Application Ref:	3/2025/0991			 Ribble Valley Borough Council <small>www.ribblevalley.gov.uk</small>
Date Inspected:	22/01/2026	Site Notice:	22/01/2026	
Officer:	MC			
DELEGATED ITEM FILE REPORT:				APPROVAL

Development Description:	Demolition of existing dwelling and erection of new detached self-build dwelling including external landscaping.
Site Address/Location:	Dilworth Cottage, Ward Green Lane, Longridge, PR3 2ZL

DRAWING TITLE  
**Proposed Elevations**

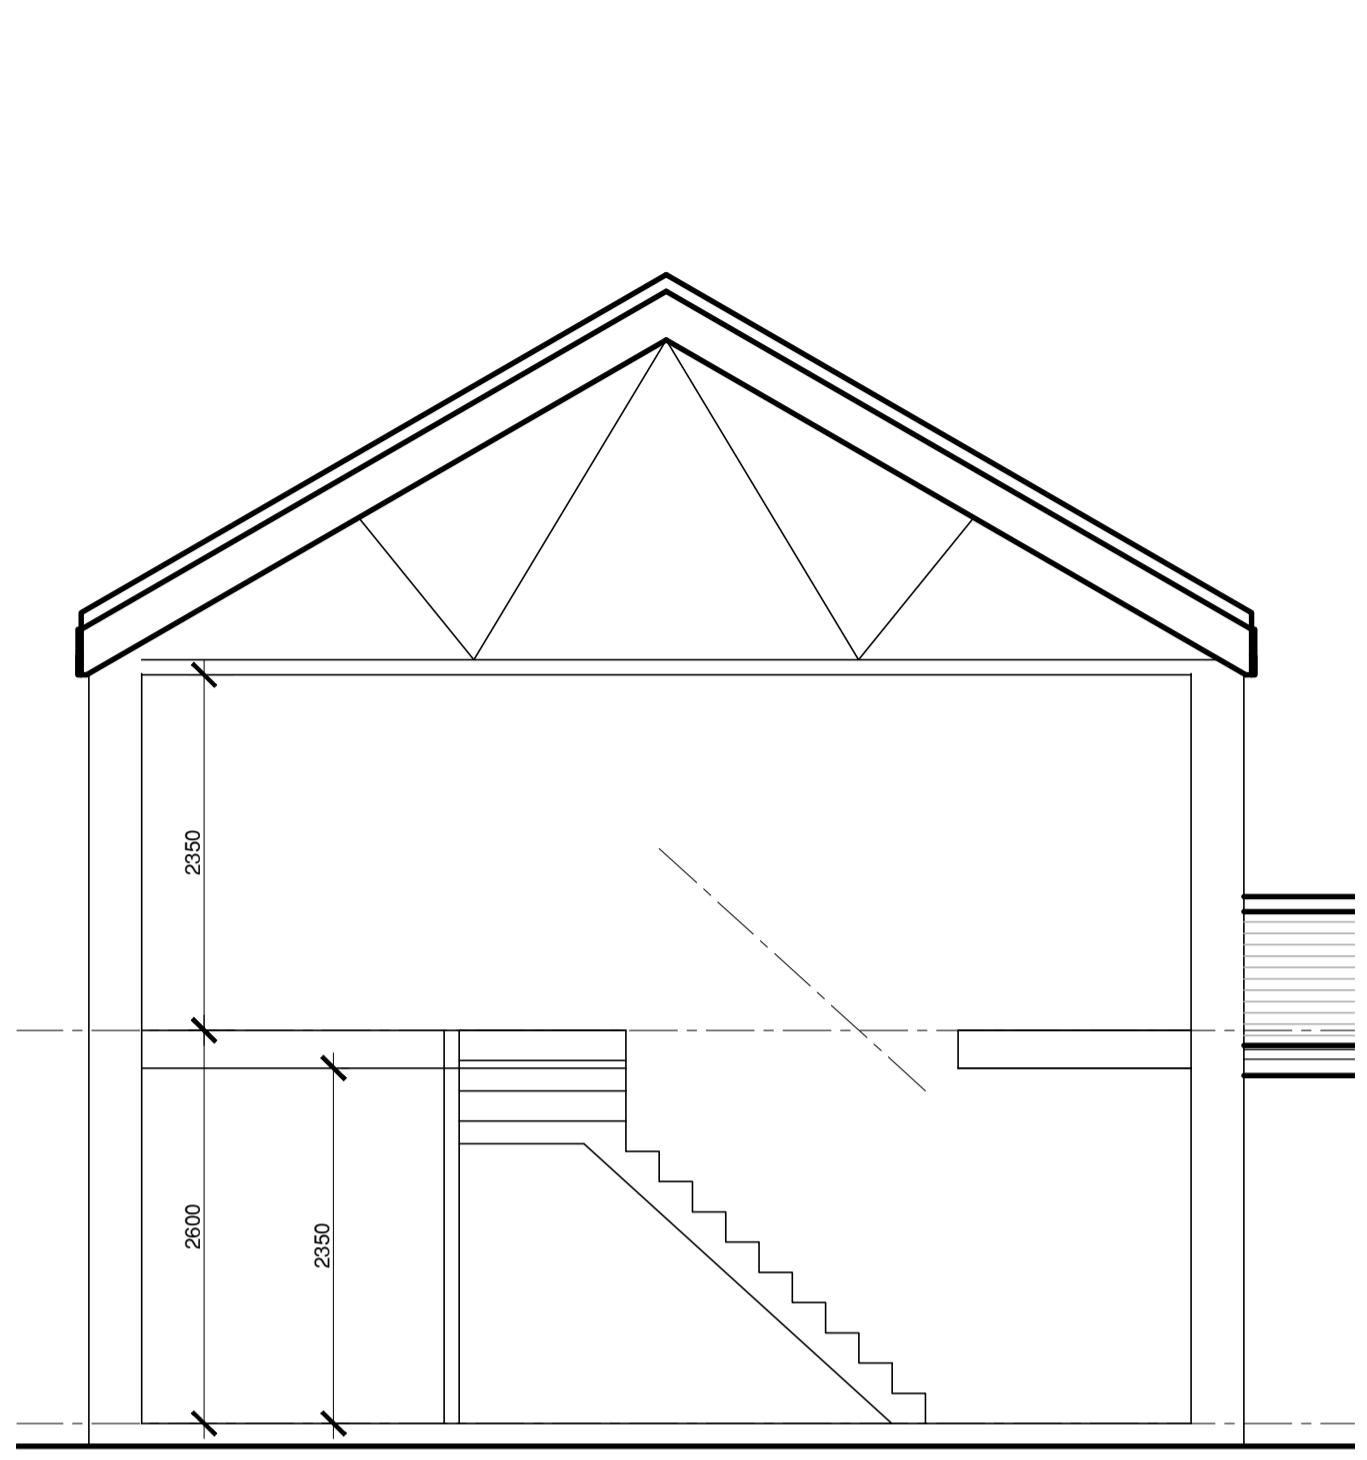
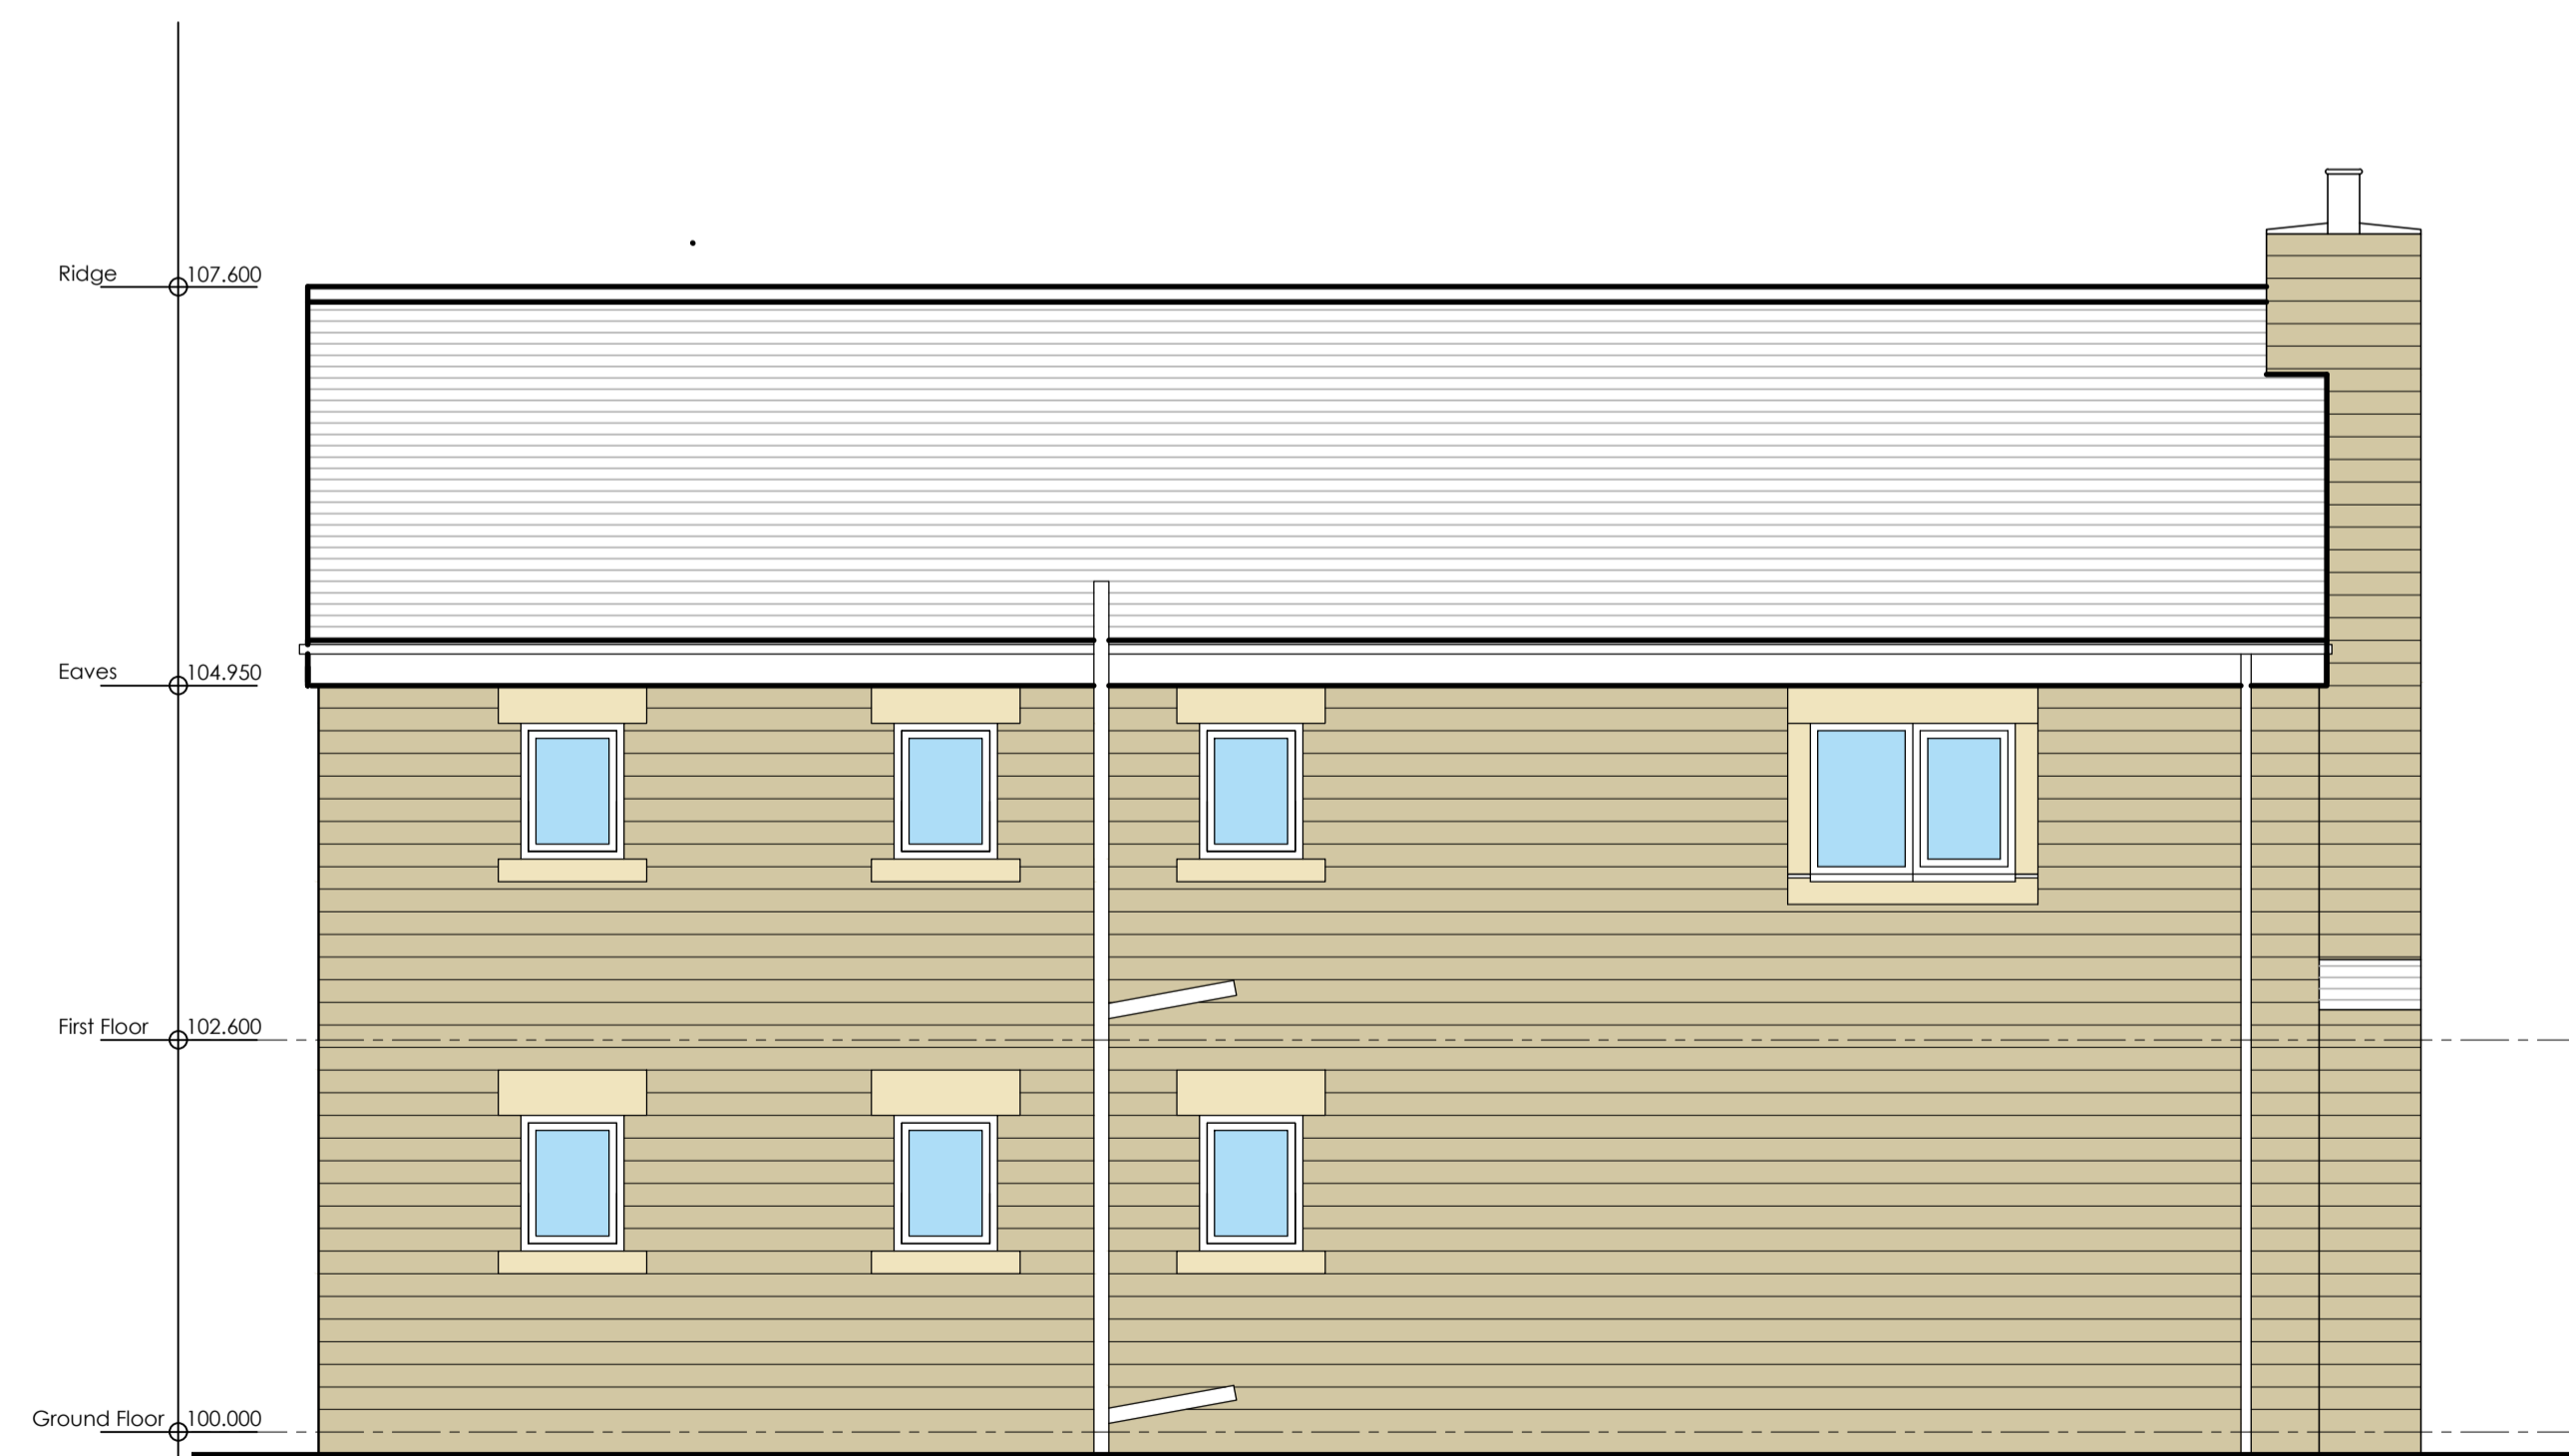
It should be noted that the plans have been amended prior to determination to remove a front gable and amend the fenestration to accommodate comments made by the Planning Officer.

Turning to the acceptability of the proposed replacement dwelling, the size and scale of the dwelling has been reduced from the refused scheme and would now be of a similar height to the existing dwelling. In addition, the front gable and bay windows have been removed from the scheme which helps to reduce the visual prominence of the dwellinghouse. The walling materials are not considered to be in keeping with the surrounding area and would not be complementary to the existing garage and wall. As such, the agent has confirmed that they are happy to agree an alternative material by way of condition. Subject to a condition to secure a sample of external materials of construction, as well as window details, the materials are considered to be acceptable.

It is also noted that the solar panels would sit flush into the roof as noted within the submitted Planning Statement and the extent of the panels has been significantly reduced from the refused scheme. As such, this element of the scheme is also considered to be acceptable.

Block Plan Scale 1:500

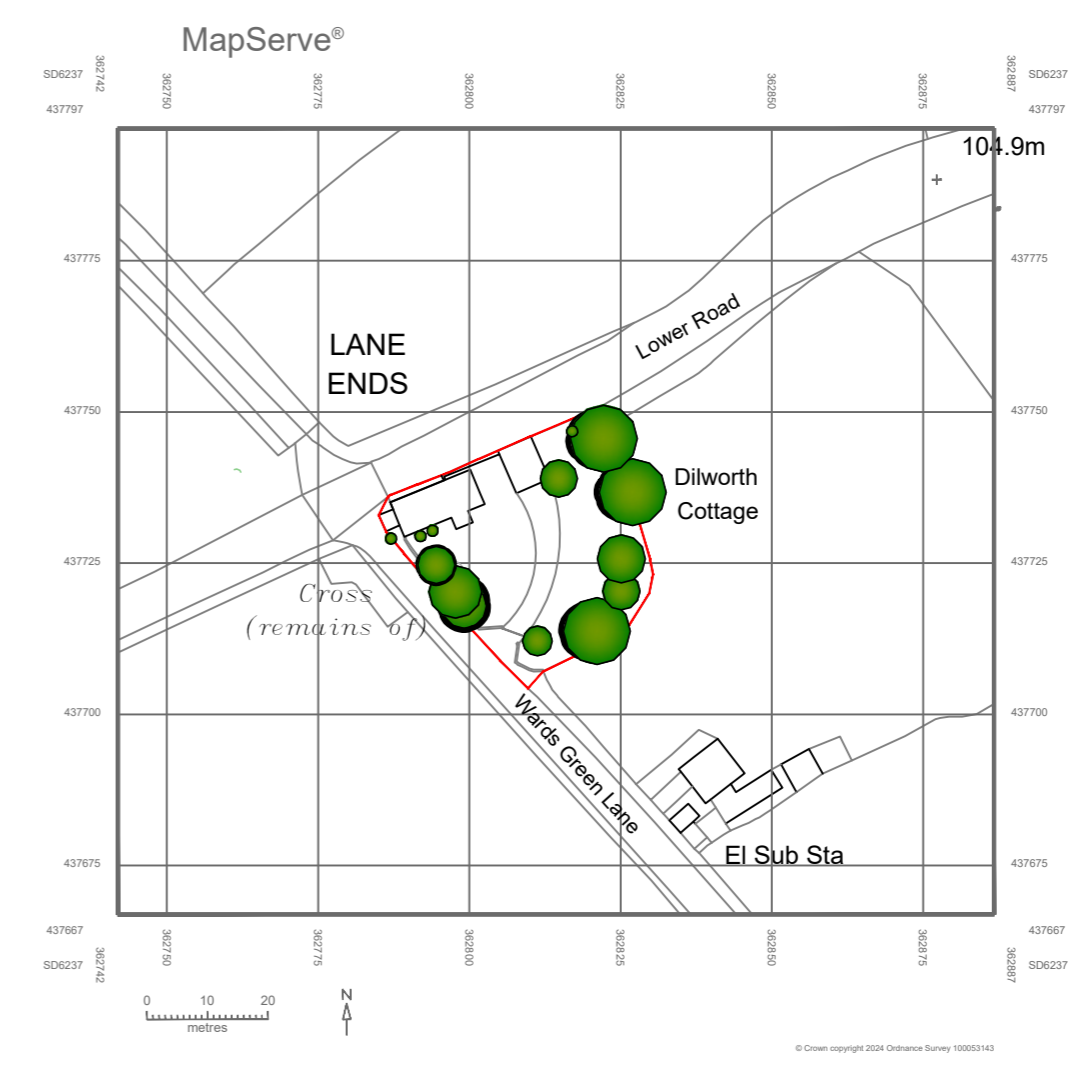
The proposed development is for the demolition of the existing dwellinghouse and the erection of a new two storey dwelling. The existing dwelling is built almost up to the boundary with Lower Road and as such, visibility at the junction is poor. The proposed new dwelling would be sited further south, leaving a gap of approximately 5.1 metres between the northern site boundary at Lower Road and the rear wall of the dwelling. In addition, the new dwelling would be sited between approximately 5.1 and 2.9 metres from the site boundary along Wards Green Lane.

Overall, the amended design of the dwelling and reduction in size and scale would introduce a more sympathetic replacement dwelling than the refused scheme and whilst the building would be brought forwards within the site and would be more visible from Ward Green Lane, the dwelling is considered to reflect the character of the surrounding area. The existing retaining wall would also now be reduced in height to 0.9m as per the amended landscaping plan to improve visibility at the junction.

The existing dwelling currently sits adjacent to Lower Road and Wards Green Lane junction. The proposal would result in the new dwelling being positioned further away from the edge of the carriageway, creating a better line of sight for vehicles at the junction of Lower Road. The retaining boundary wall adjacent to Lower Road will be lowered to 0.9m which would assist in visibility at the junction allowing drivers to see over the wall and observe oncoming traffic. The LHA consider that amendments to the retaining wall fronting Lower Road will require the applicant to provide a structural report setting out how any structures will be assessed, excavated, constructed, strengthened or demolished and secured by way of planning condition.
